Please ask for: Ms Iqraa Malik
Email: iqraa.malik@terraquest.co.uk
Telephone: 01212341390
Our Ref: AW/98/21/HH
Your Ref:
Date: 24th March 2021

Application for Planning Permission for Works or Extension to a Dwelling

Development: Proposed single storey side/rear extension.
Location: 4 Leecroft Aldwick PO21 3SY

EXISTING GROUND FLOOR PLAN

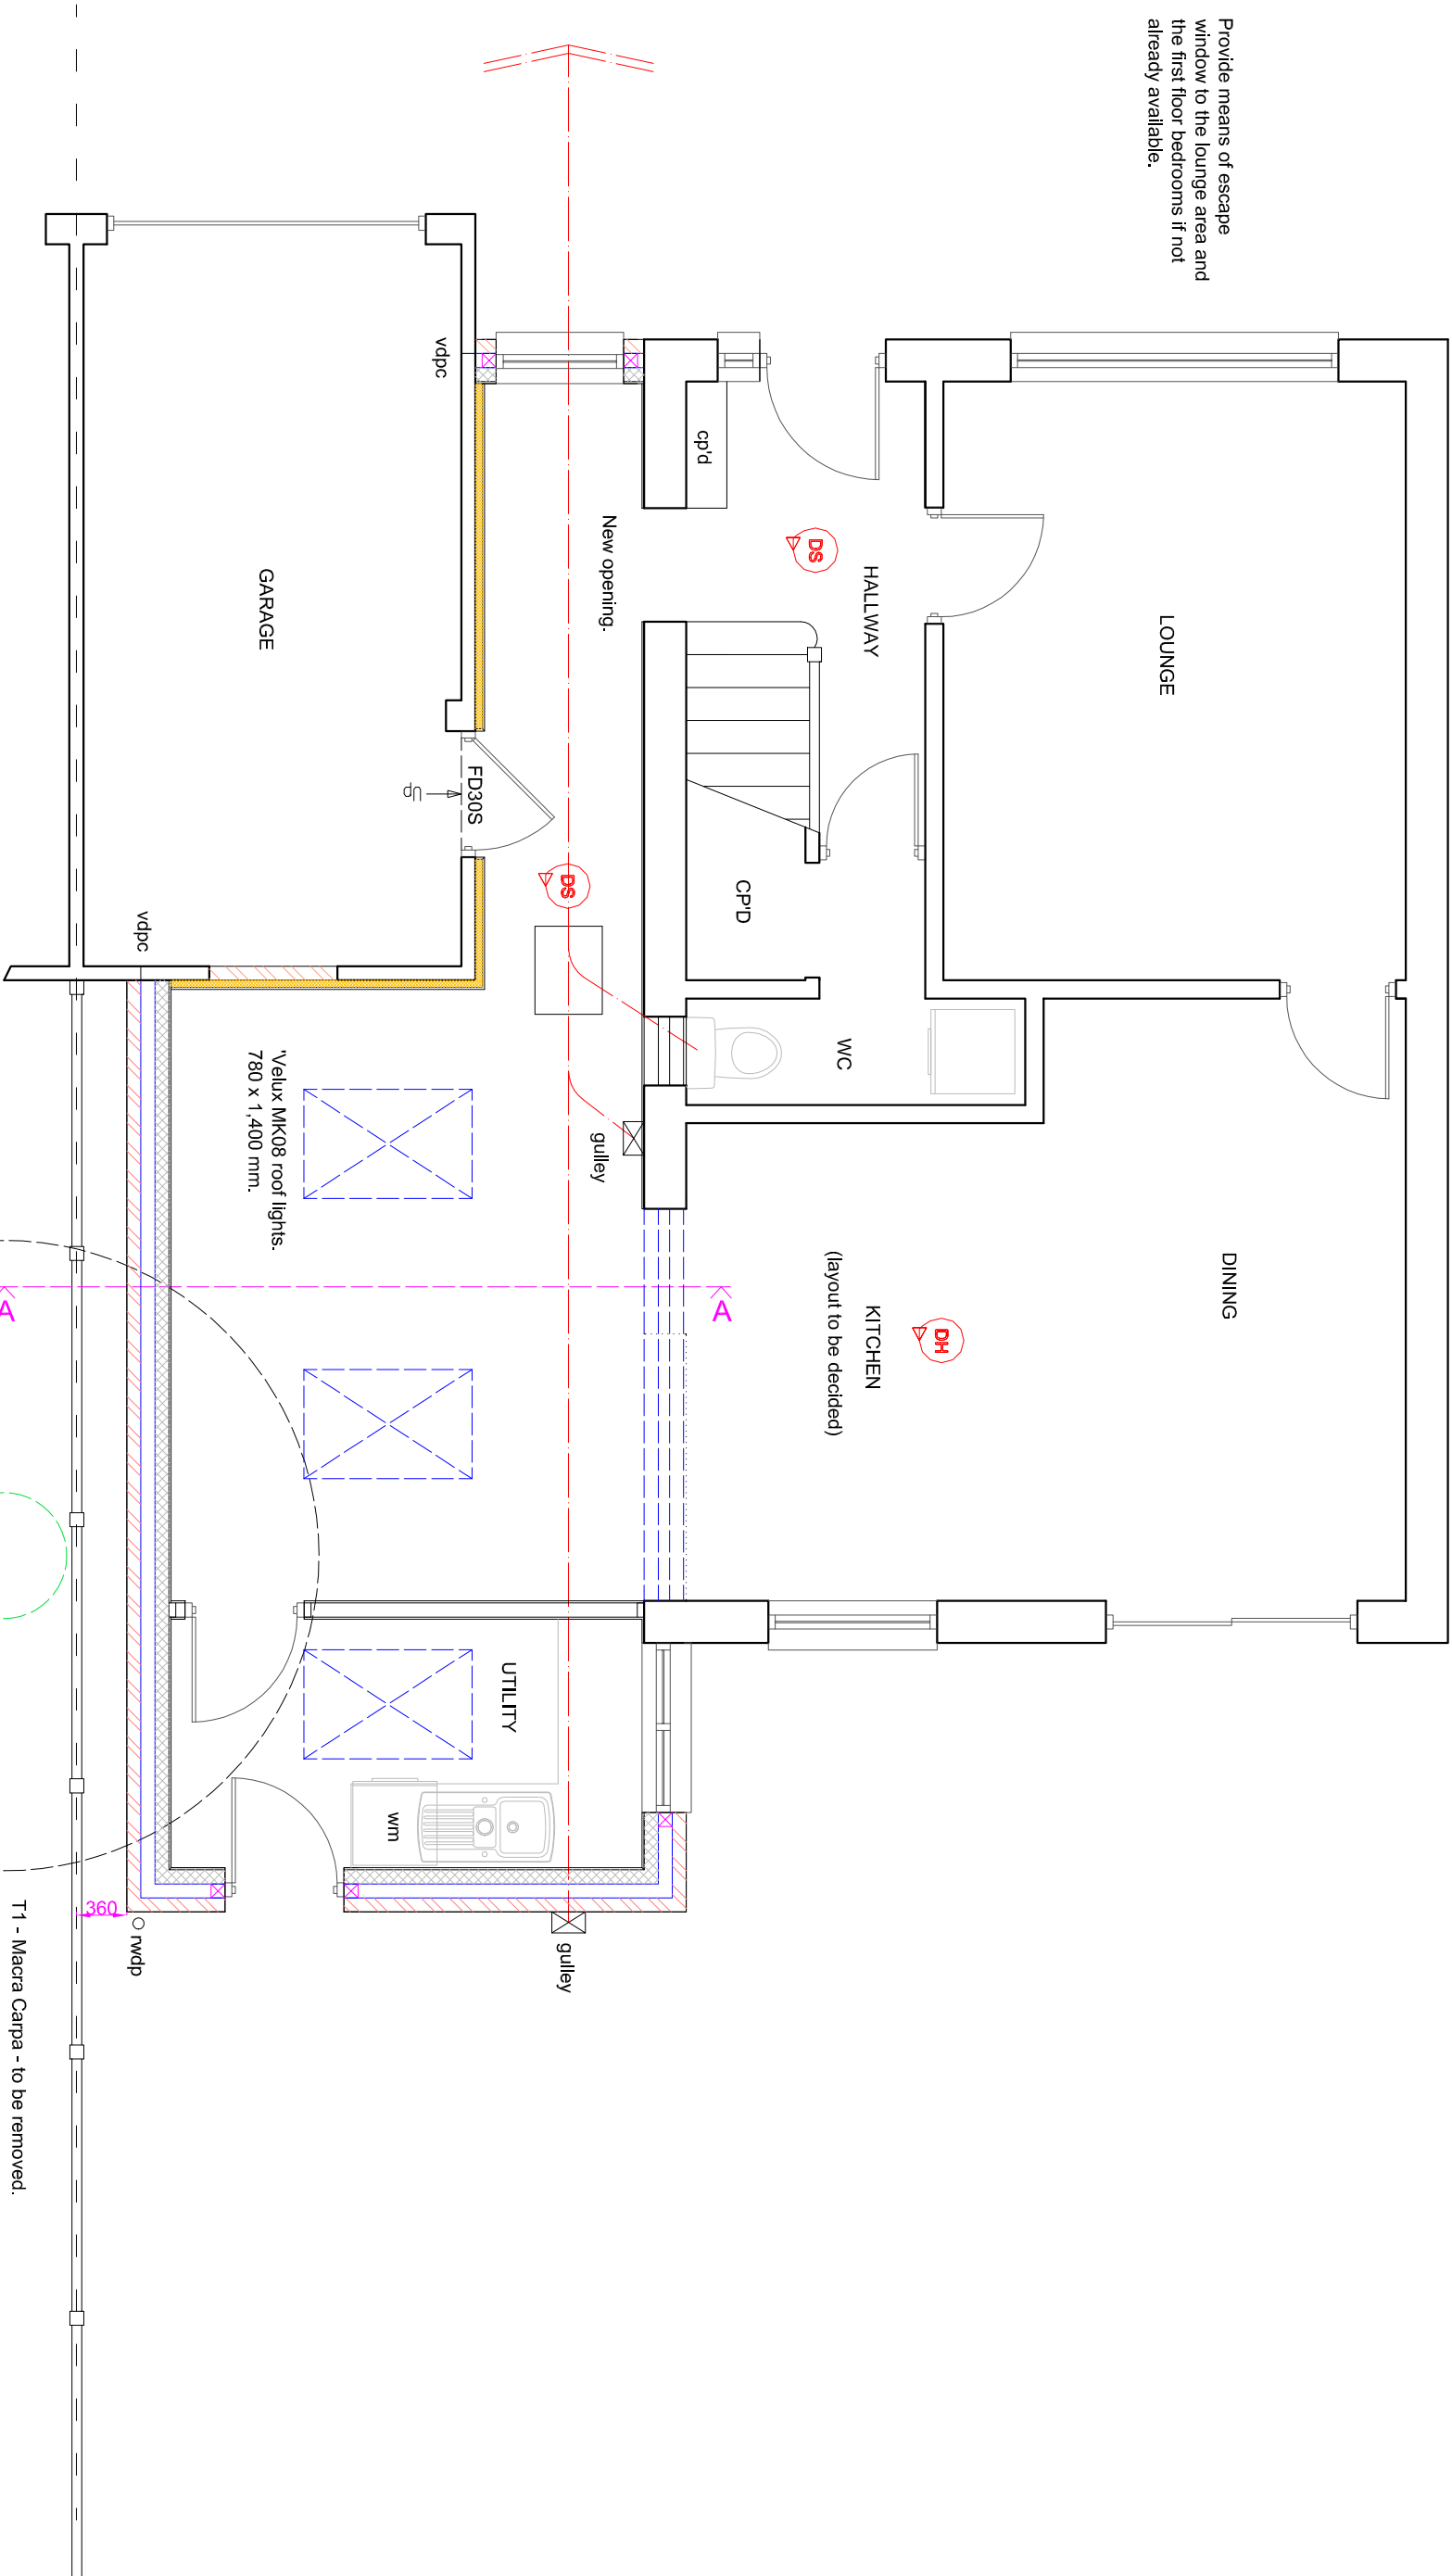
Inconsistent: The extension does not match between the block plan and all other plans

SITE PLAN - 1/500

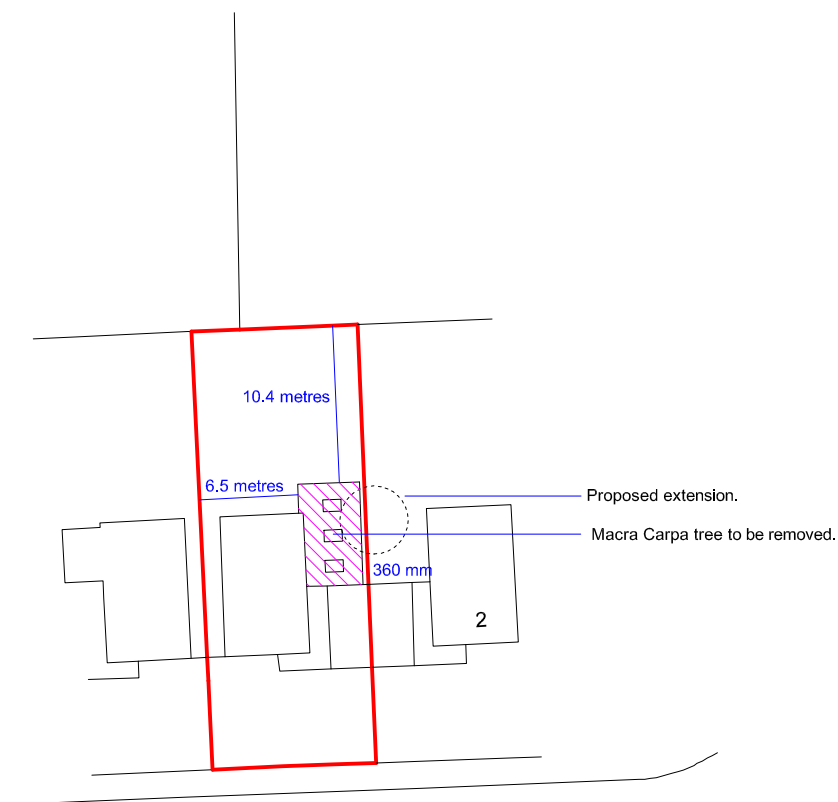
Dimensions: You are required to include a dimension to the front boundary.
